Our ref: HMS ID 7925

Advice on Modification Report – State Significant Development

Proposal: Gregadoo Solar Farm MOD 4

Major Project reference: SSD-8825-Mod-4

Figure 22 – Location of the Gregadoo Ring Tree

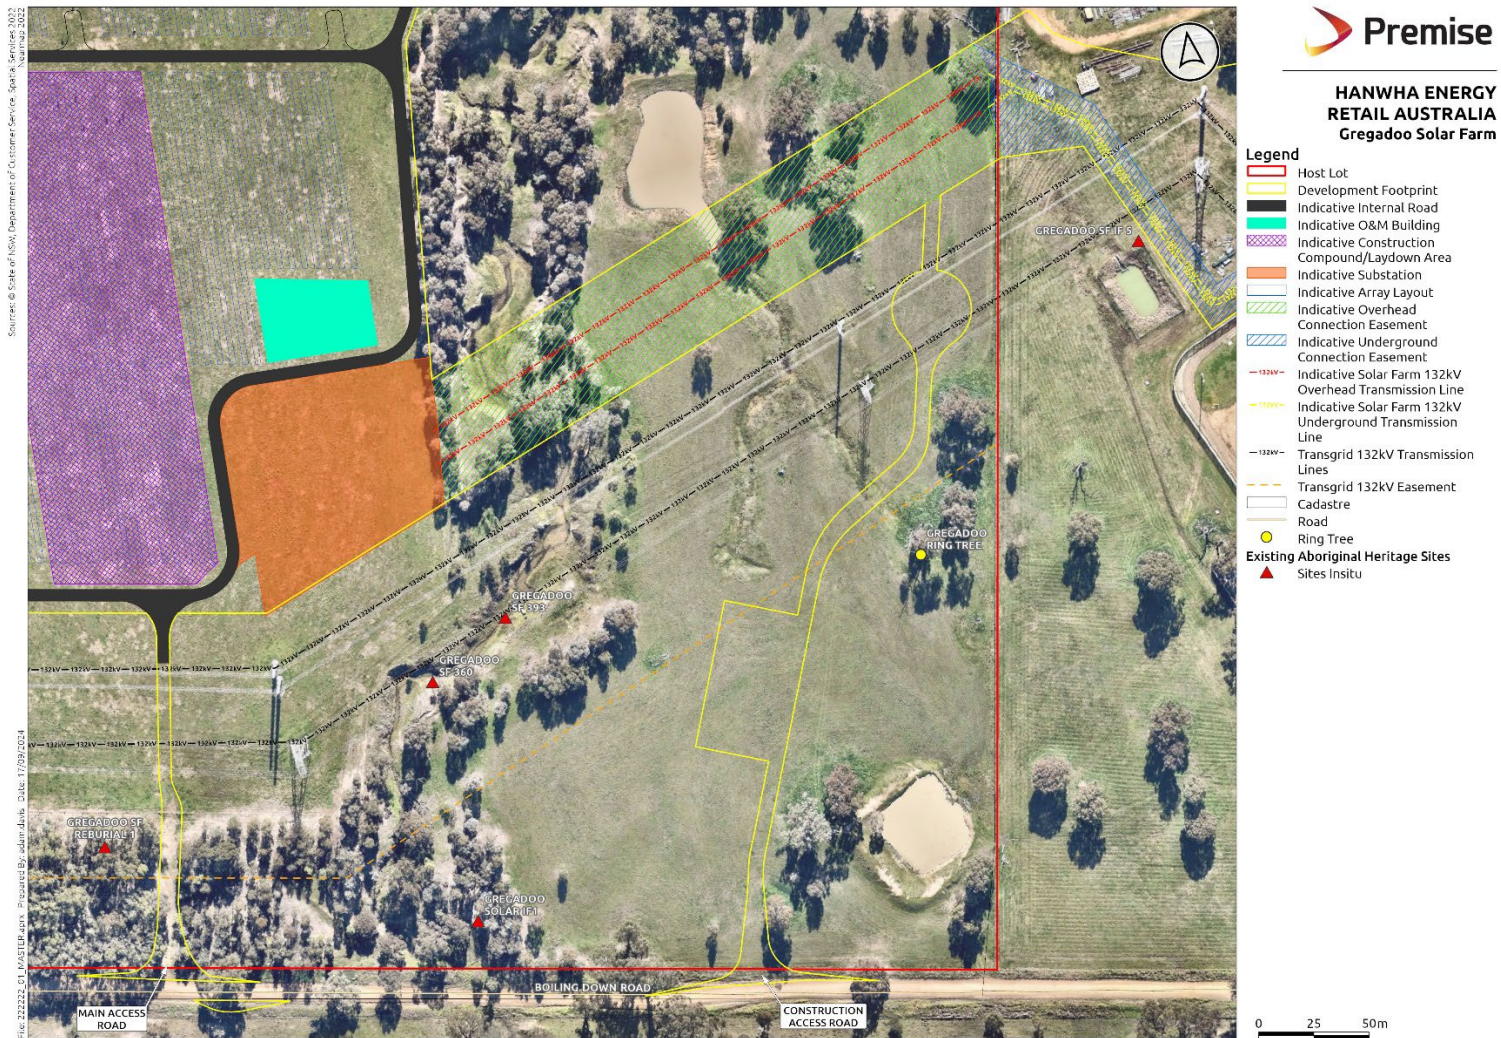
The Modification Application states that the addition of the BESS will not result in any additional impacts to Aboriginal cultural heritage within the approved project footprint. A survey of the proposed access track undertaken for the AHDDA identified one potential ring tree (recorded as Gregadoo Ring Tree). The proposed access track was realigned to avoid impact to the site, and a survey of the new alignment did not identify any additional Aboriginal sites. Please note that Heritage NSW generally does not accept Due Diligence assessments for SSD projects, however as this report includes consultation with the Registered Aboriginal Parties (RAPs) and forms an addition to existing Aboriginal Cultural Heritage Assessment Reports (ACHAR) and addendums, the assessment is sufficient for the proposal.

- Appendix 3: Aboriginal Heritage Sites - Update the existing figures to include Gregadoo Ring Tree.
- Appendix 4: Aboriginal Heritage Items – Update *Table 1: Aboriginal heritage items – avoid impacts* to include Gregadoo Ring Tree.
